Arun District Council
Arun Civic Centre
Maltravers Road
Littlehampton
West Sussex BN17 5LF
Planning & Building Control General Enquiries
Tel: (01903) 737756 Fax: (01903) 730442
Dx: 57406 Littlehampton
Minicom: 01903 732765
e-mail: planning@arun.gov.uk
website: www.arun.gov.uk/planning

Application No: A/193/20/PL
Site Address: Ham Manor Cottage Ham Manor Way Angmering BN16 4JQ
Description of works: Erection of a 1 No. 3 bedroom chalet bungalow & detached garage. This site is in CiL Zone 3 and is CIL Liable as dwelling.

Thank you for your internet representation made on 12th February 2021 which has been recorded as an objection with the comments as follows:

Revision:	A	Dec 2020	Dimension added
address	Ham Manor Cottage, Ham Manor Way, Worthing, West Sussex		
project	Proposed construction of 3 bedroom detached property with detached double garage		
title	Proposed Block Plan		
scale	date	dwg no.	revision
1:200 on A4		2020.275.02	A

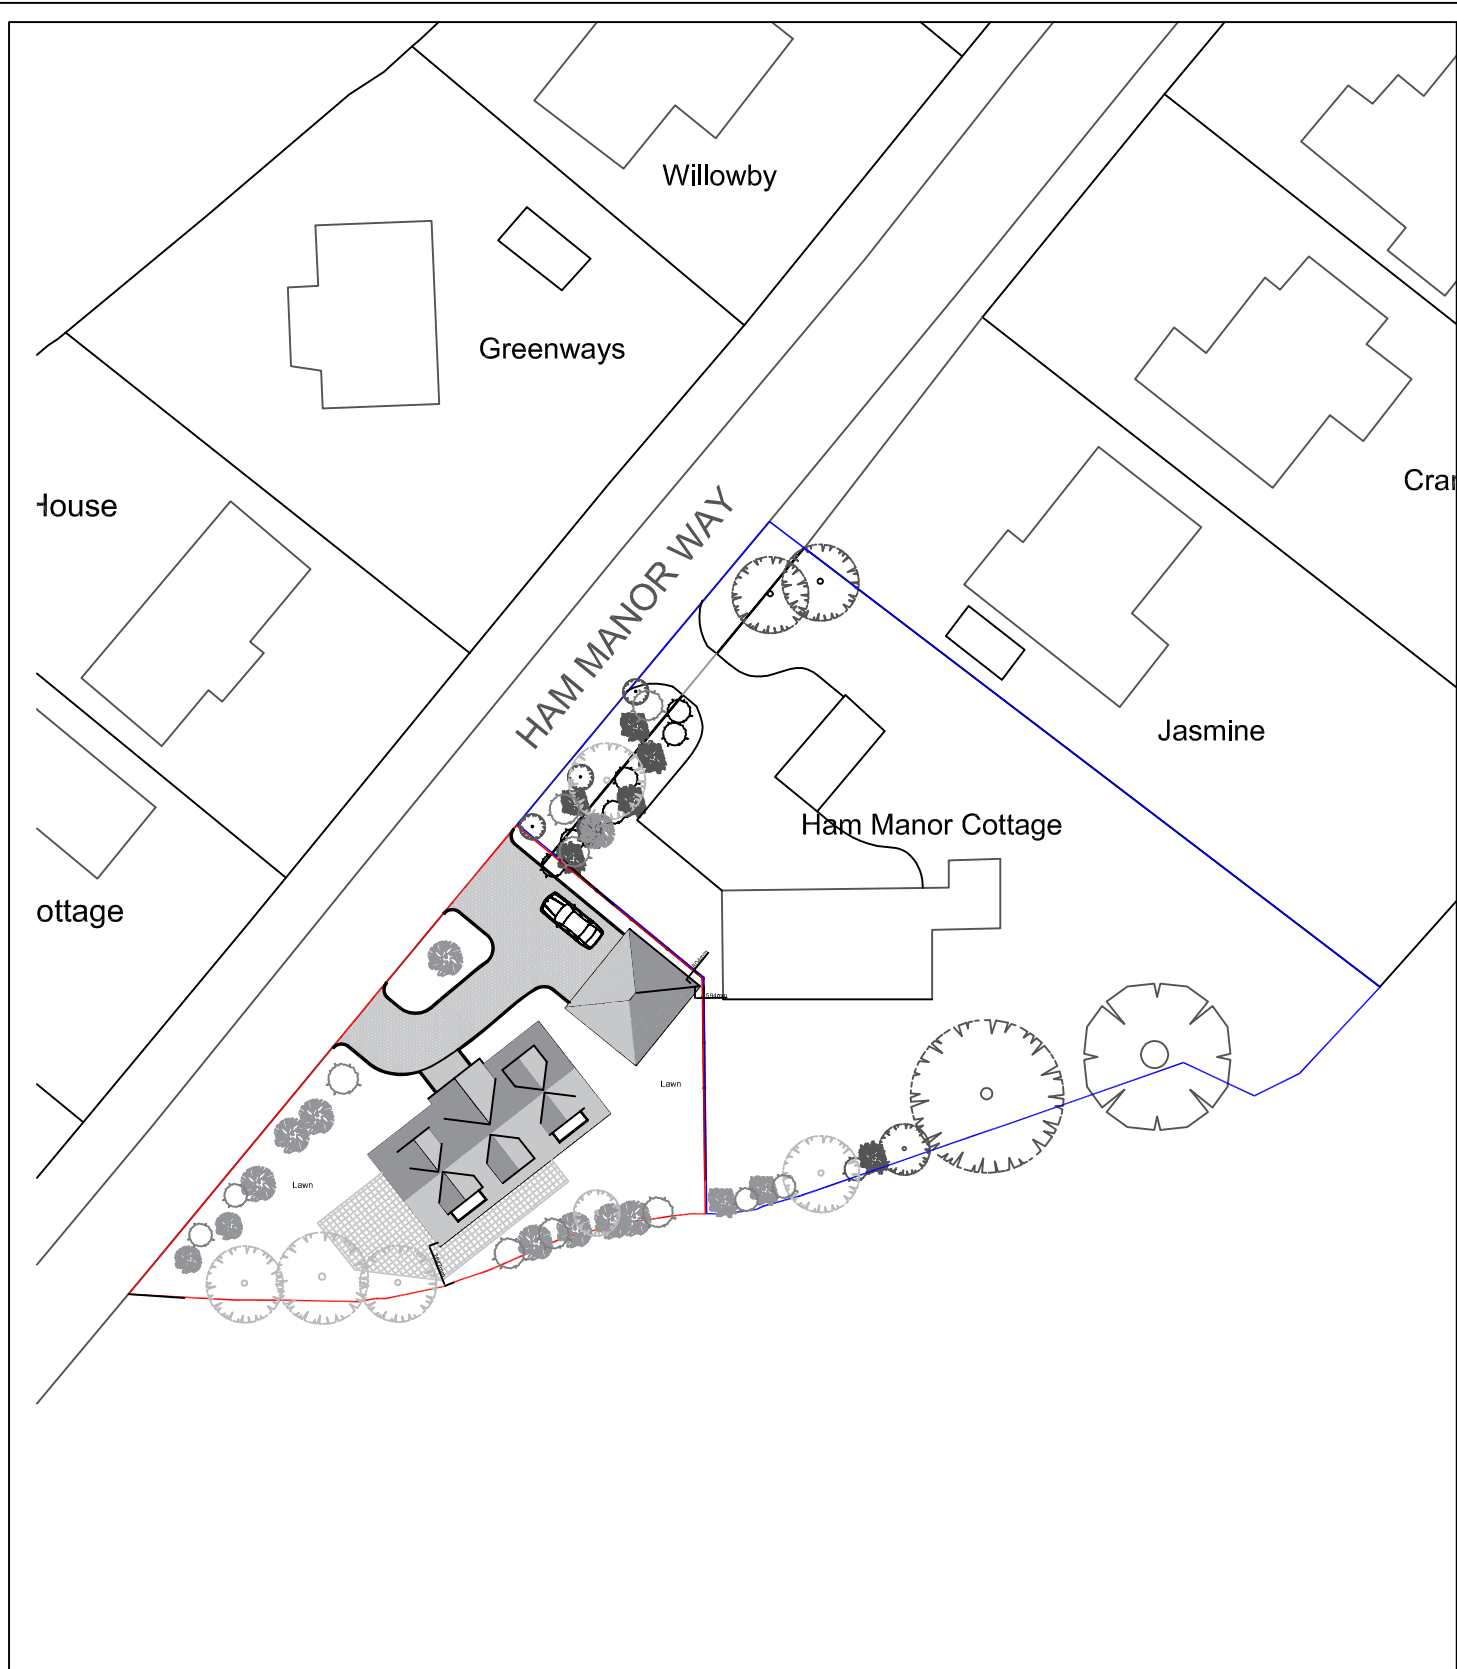
Forgive me for stating the obvious but the plan shows the building extending forward well beyond the existing building line, this I believe would not be acceptable.
